**Stonewalls
Bonds End Lane
Sibford Gower
Banbury
OX15 5RT**

18/00550/F

Proposal: Erection of single storey extension to replace single storey extension

CLIENT	Mr M Smales	SCALE	1:100 @ A3	DATE	December 2014
PROJECT	Stonewalls, Bond End Lane, Sibford Gower, OX15 5RT	DRAWN	MH	CHECKED	MH
DRAWING TITLE	Elevations	JOB NUMBER	1306	DRAWING NO.	14
	As Proposed Option 3			REVISION	C

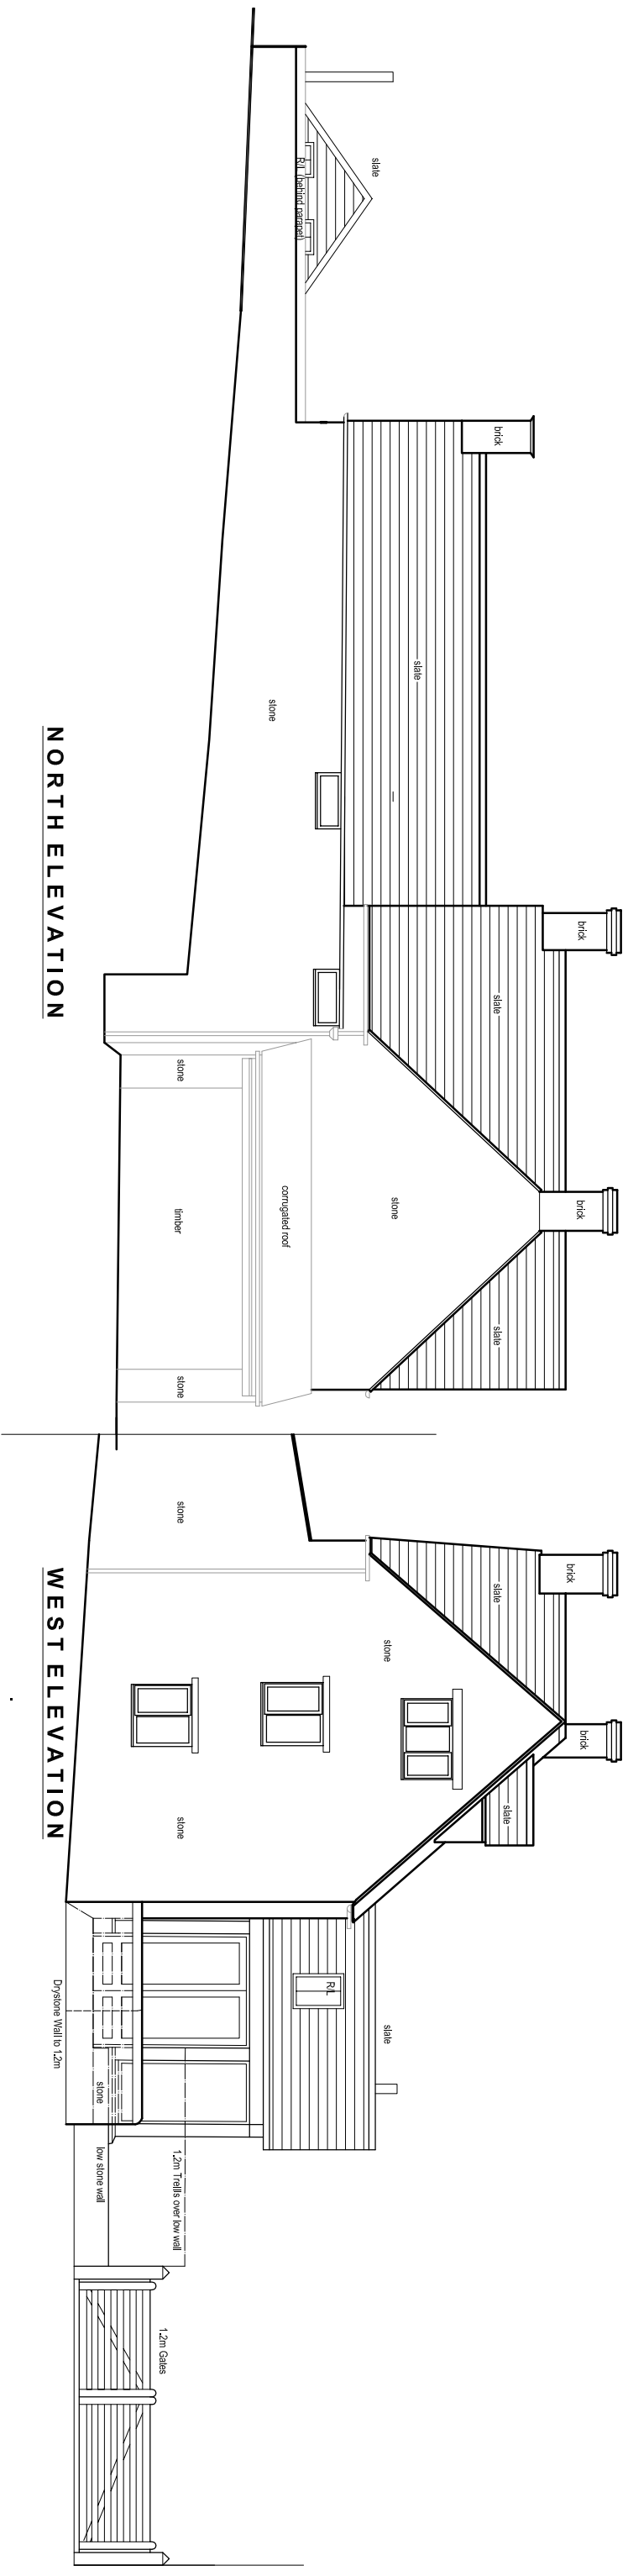
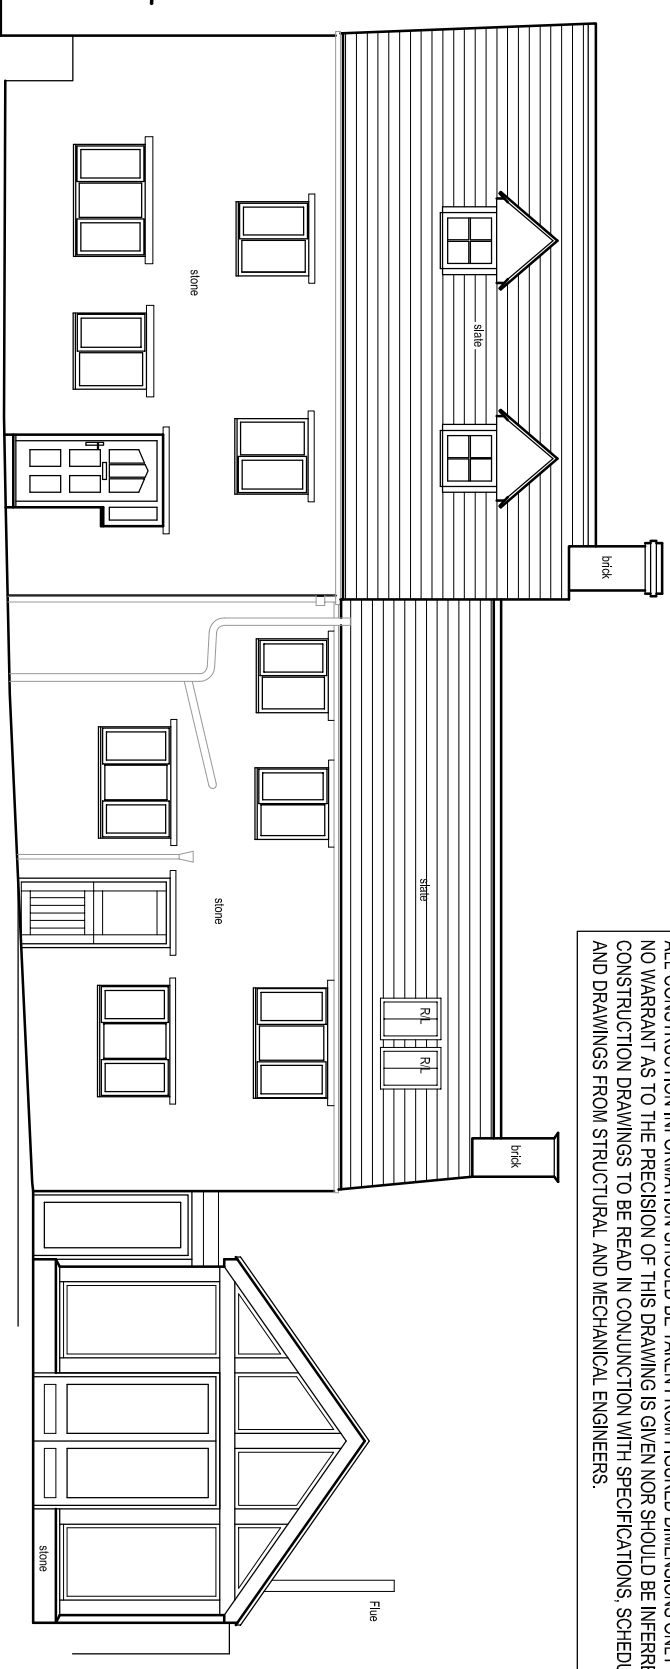
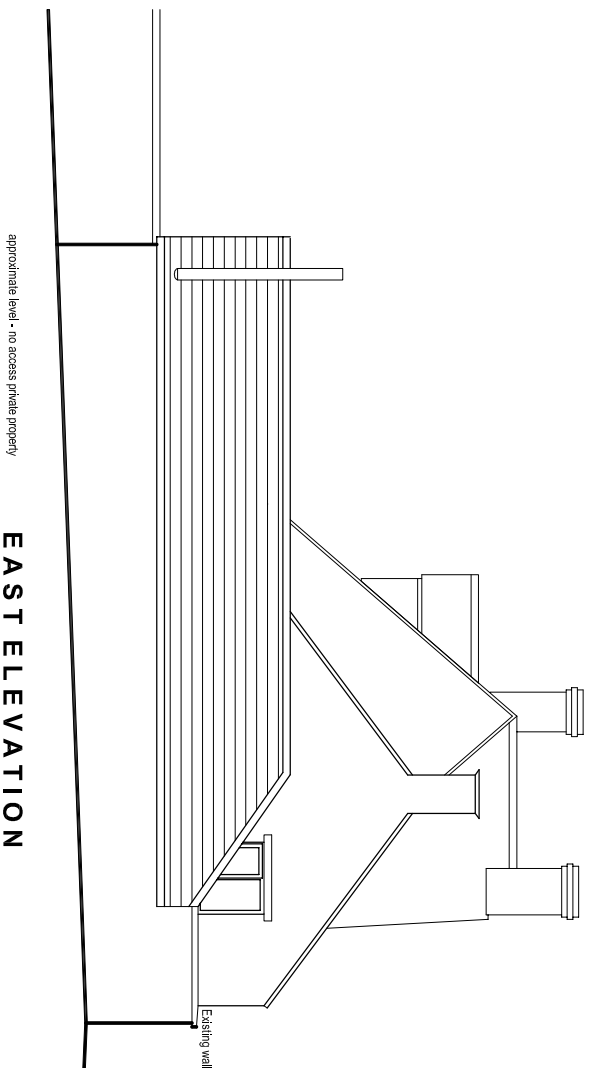
My initial thoughts are the proportions and height of the fenestration to the glazed office is too tall for a modest vernacular cottage. I recommend that the eaves are

lowered, which may require the articulation/proportions of the glazing panels to be adjusted. The glazed link would be more successful if it was recessed to create a deeper shadow between the cottage and the glazed office.

The height of the plinth looks shallow resulting in a very thin panel to the bottom of the glazed door. The options would be to increase the height of the plinth which would in turn require the glazing panels above the plinth to be narrower so that the proportion does not look odd; or omit the panel and just have a deeper base.

If the Applicant is set on a panel at the base of the door, the height of the panel should be taller than the mid-rail; and the bottom rail of the door should be taller than the mid-rail. Once this has been worked out, the height of the plinth can be set and together with the lowered eaves, the proportion of the fenestration can be confirmed (ideally based on the Golden Section or Euclidian Geometry etc) which enhances the 'host' building, rather than dominates it.

There is a hedge to the side of boundary which provides a screen to the site but it would be seen from the lane. Oddly, it has been set slightly off the door axis. I did not gain access to the adjoining property to see the impact the flue would have as there is an excessive amount of the flue above the roof. In terms of impact it might be less visible sited to the north and should be coloured a matt black/dark charcoal grey.

The proposed rooflights look awkward on the principal south elevation, and would be seen from the lane. The proposed master bedroom has windows to the north and east; rooflights are also noisy when it rains. I recommend these are omitted.

The proposed rooflight to the west roof slope of the conservatory is not necessary and makes the roof too fussy. Adequate daylighting will be provided by the gable and glazed walls/doors. I recommend these are omitted.

7. The flue for the wood burning stove shall be painted matt black prior to the first occupation of the extension hereby approved and retained as such in perpetuity.

REVISION	DATE	DRAWN	CHECKED	DESCRIPTION
CLIENT	Mr M Smales			
PROJECT	Stonewells, Bond End Lane, Sibford Gower, OX15 5RT			
DRAWING TITLE	Ground Floor Plan			
	As Proposed Option 3

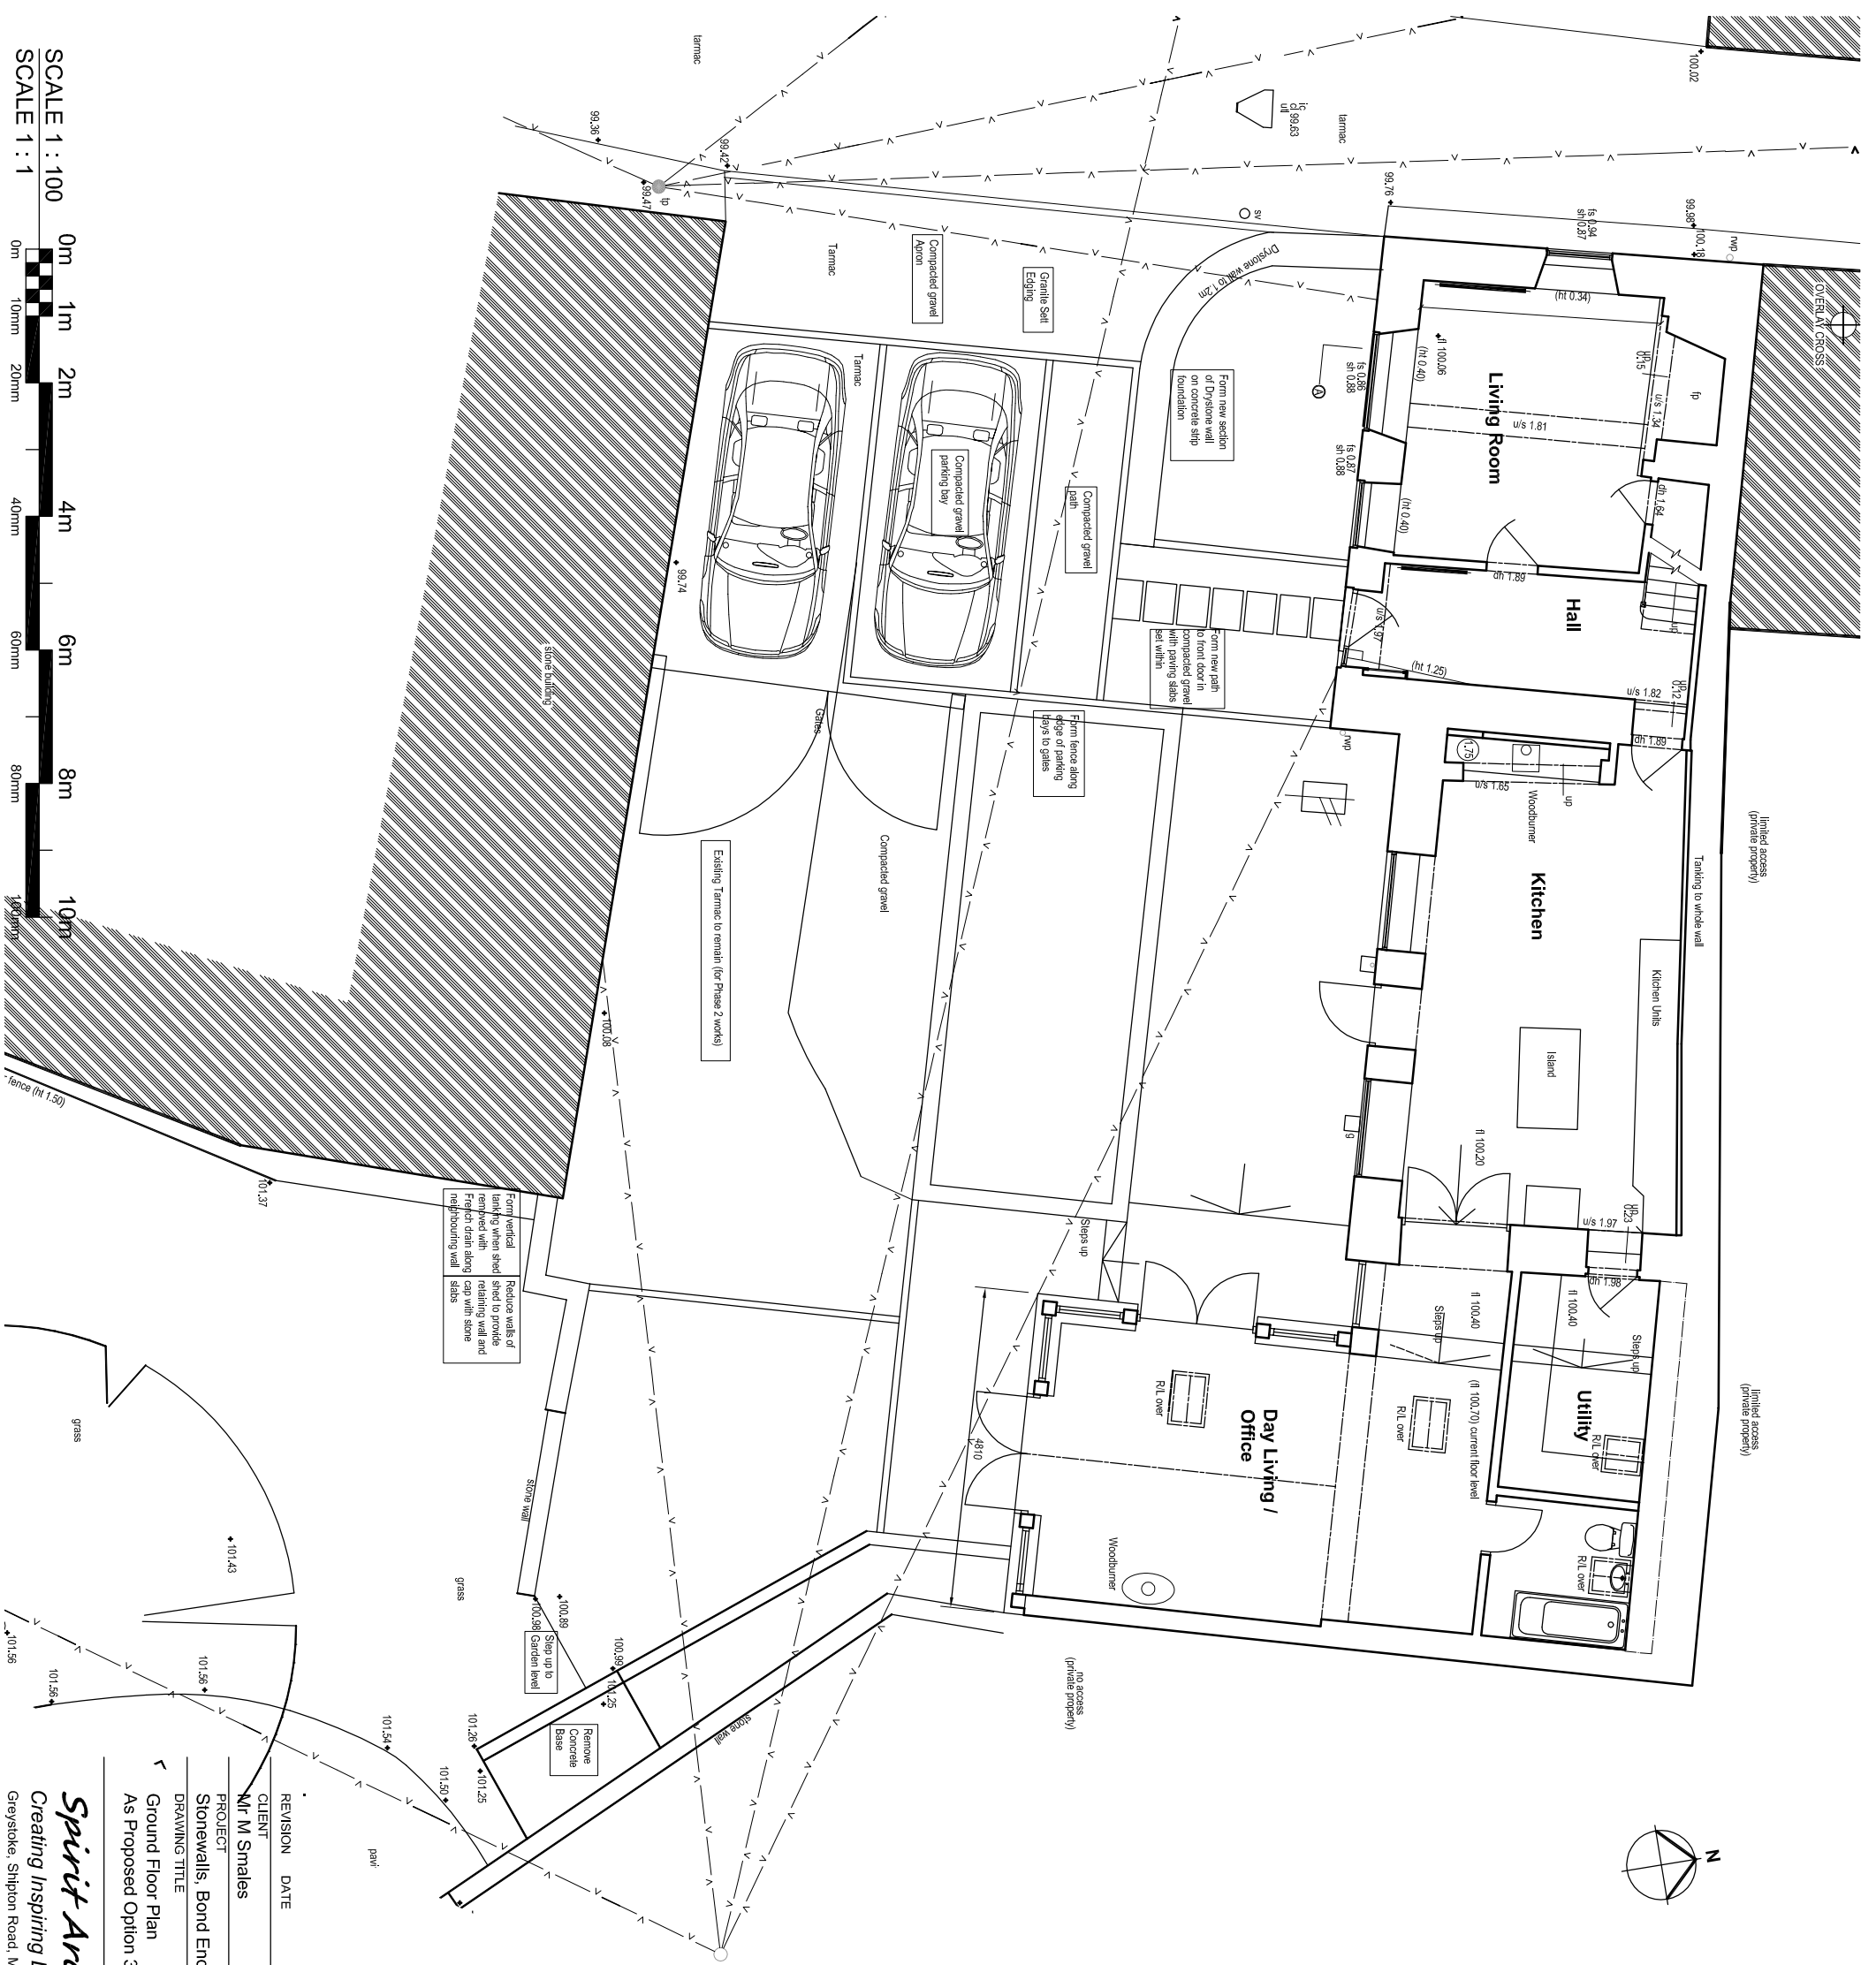
The colour palette, layout and material should be traditional for the area and harmonise with the stone of the cottages.

Gates: Are the existing gates being reused, if not please provide details.

8. Prior to the construction of the extension hereby approved, the existing means of access between the land and the highway shall be improved in accordance with the detail shown on drawing 12 Rev. C, formed, laid out and constructed strictly in accordance with Oxfordshire County Council's specification and guidance.

9. The parking area shown on drawing 12 Rev. C shall be kept free of obstructions at all times and used only for the specified purpose.
